9 September 2020

SF2020/009595; WST20/00007/04

**SSD 20415: Lot 21 DP 704061, Mitchell Highway (HW7), Nyngan  
Proposed Yarren Hut 28 MW Solar Photovoltaic Farm, 66 kV electrical sub-transmission  
line and three lot (3) subdivision**

Figure 8.2: Rural basic left-turn treatment (BAL)

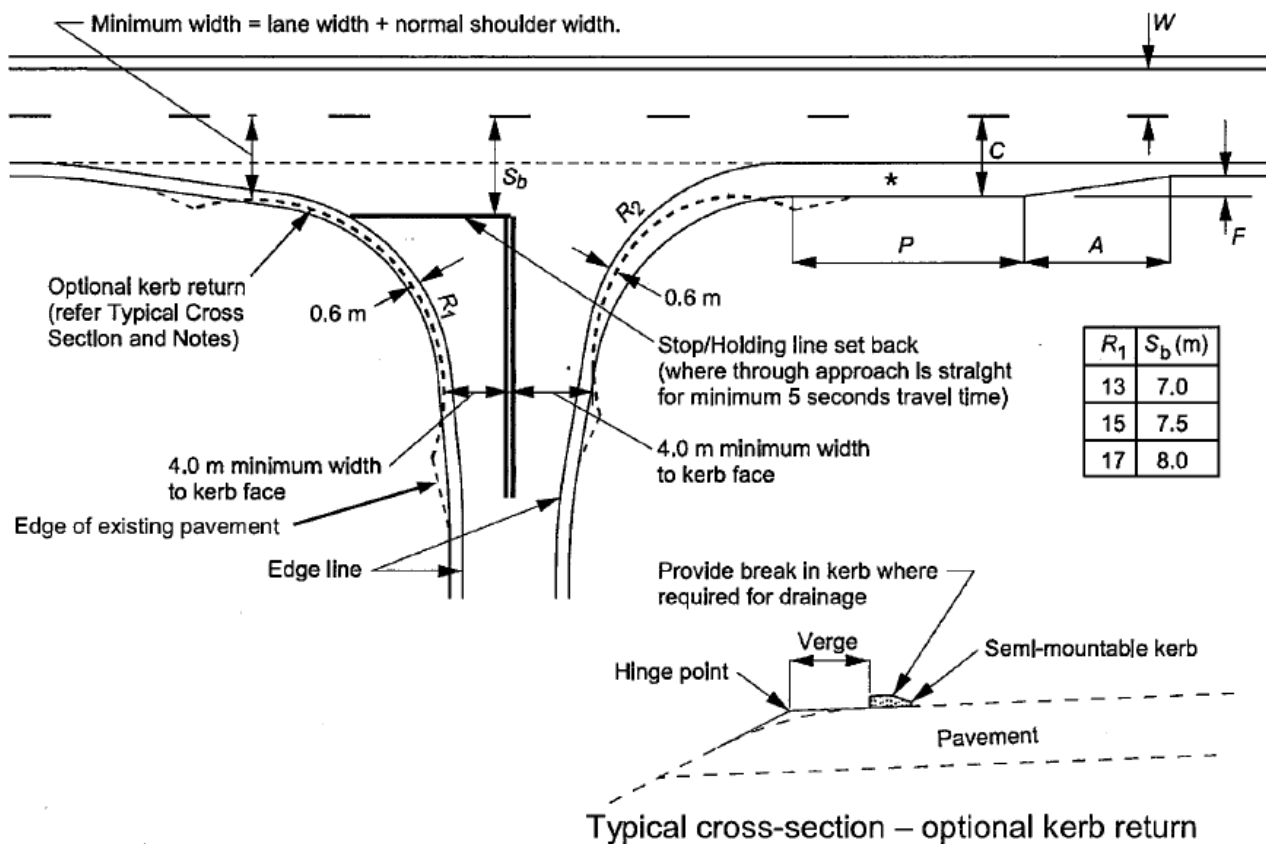
- A Basic Left (BAL) turn treatment as shown in Figure 8.2 in accordance with *Austroads Guide to Road Design Part 4, 2017* (copy enclosed) and relevant TfNSW supplements to *Austroads*. The intersection works are to be designed and constructed for a 110km/h speed environment and be able to accommodate the largest vehicle accessing the site. Noting this may be subject to change from a Type 1 road train 42 metres to accommodate are larger configuration of heavy vehicle.

Figure A 28: Basic right (BAR) turn treatment on a two-lane rural road

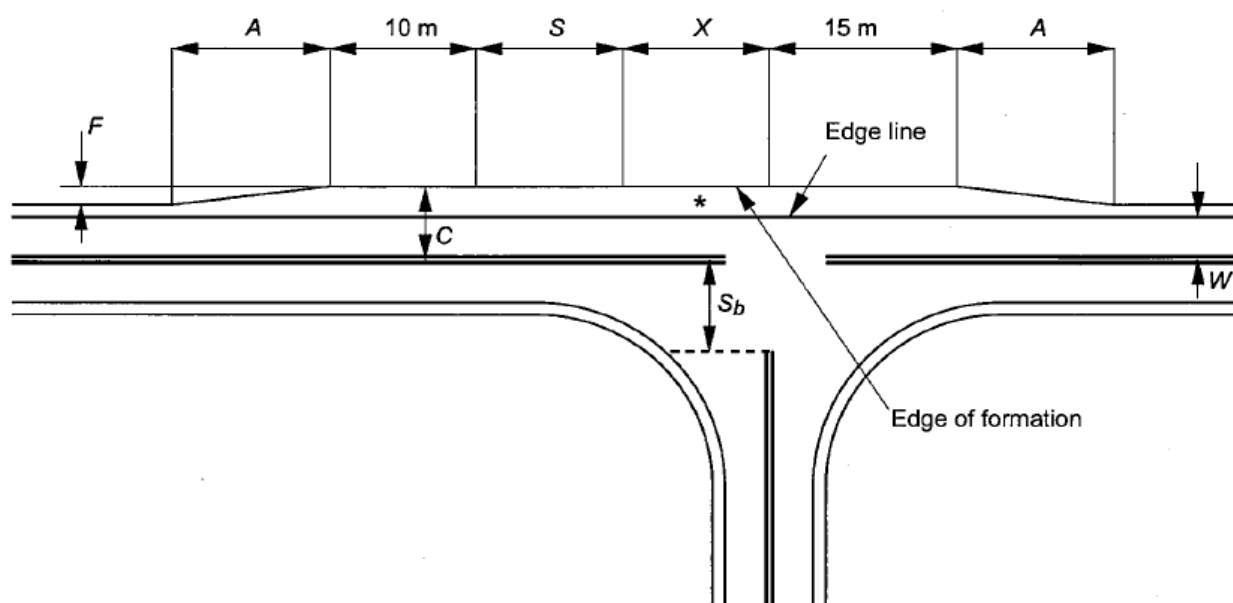
- A Basic Right (BAR) turn treatment as shown in Figure A 28 in accordance with *Austroads Guide to Road Design Part 4, 2017* (copy enclosed) and relevant TfNSW supplements to *Austroads*. The intersection works are to be designed and constructed for a 110km/h speed environment and be able to accommodate the largest vehicle accessing the site. Noting this may be subject to change from a Type 1 road train 42 metres to accommodate are larger configuration of heavy vehicle.
